# KITTITAS COUNTY FIRE MARSHAL'S OFFICE

Re: Mellergaard (SG-12-00001)

After conducting a review of the above named project, I have the following comments:

SEGREGATION SURVEY
 PREPARED FOR
 L. BRIAN MELLERGAARD
 A PORTION OF SECTIONS 3, 9 & 10
 TOWNSHIP 17 N., RANGE 18 E., W.M.

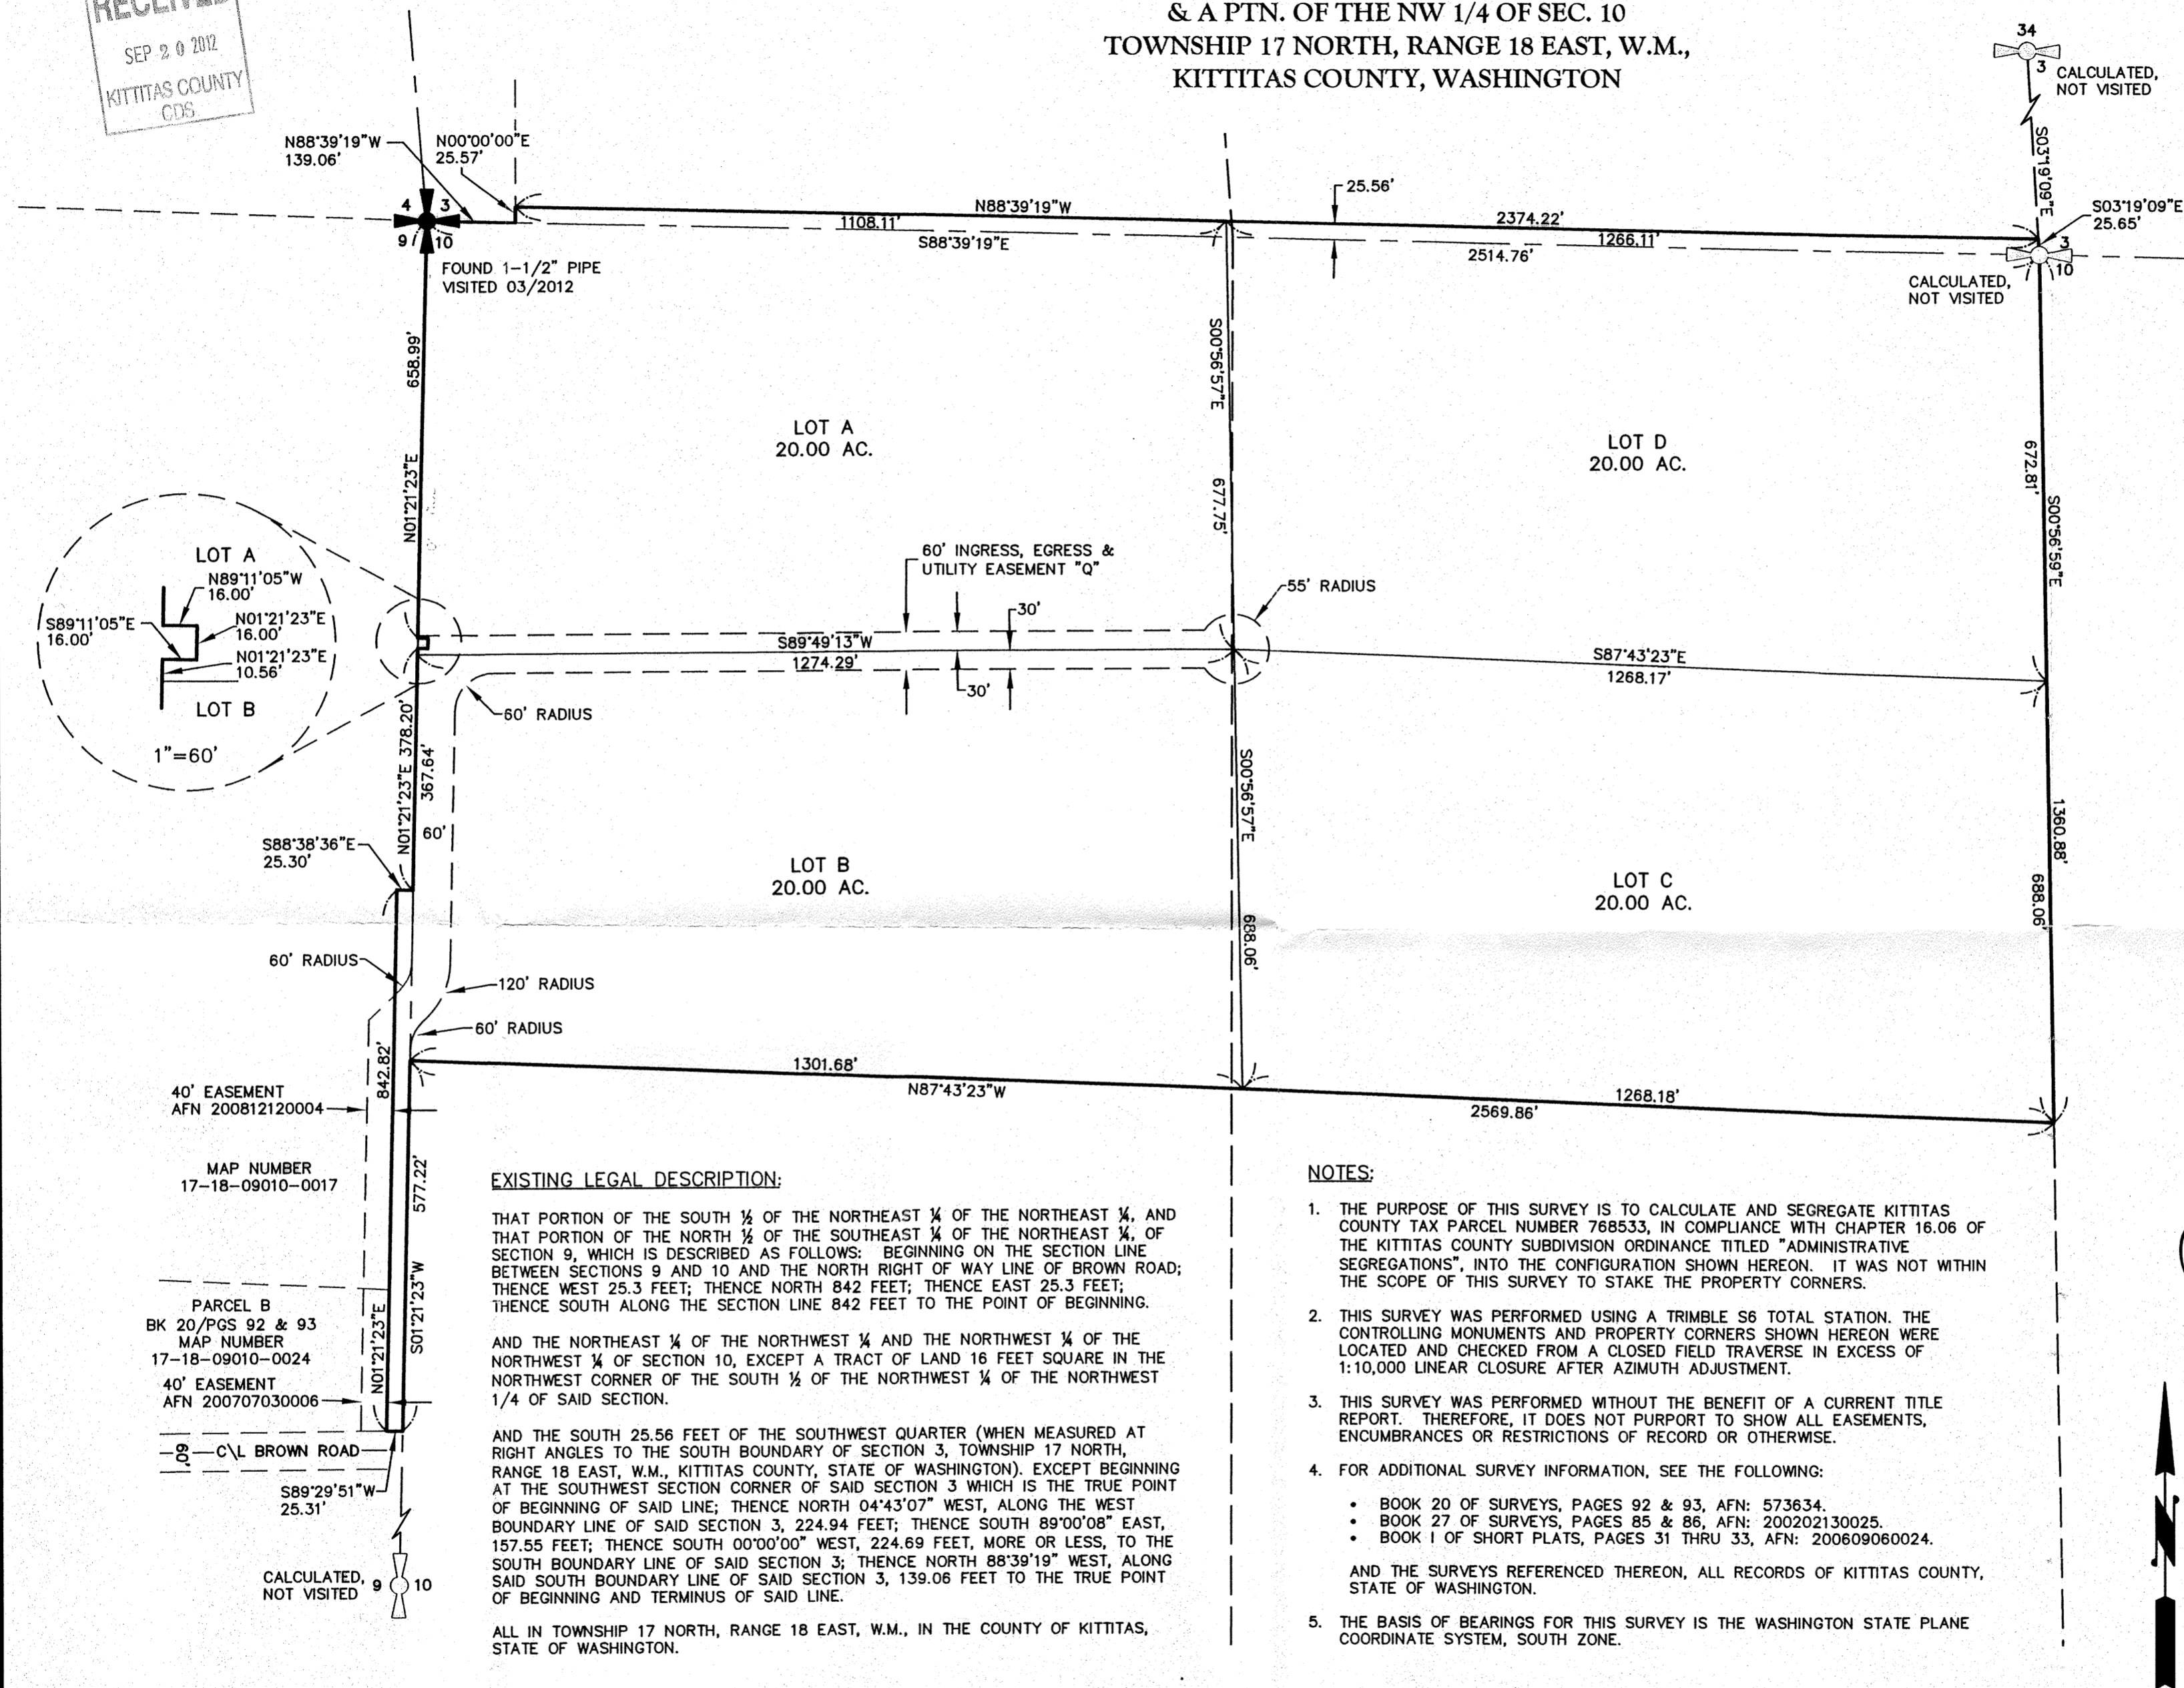
- Ensure that the segregation does not infringe upon existing structures, to include propane tanks, etc.
- Creation of any additional roads or access must comply with the International Fire Code.
- All future development must comply with the International Fire Code.
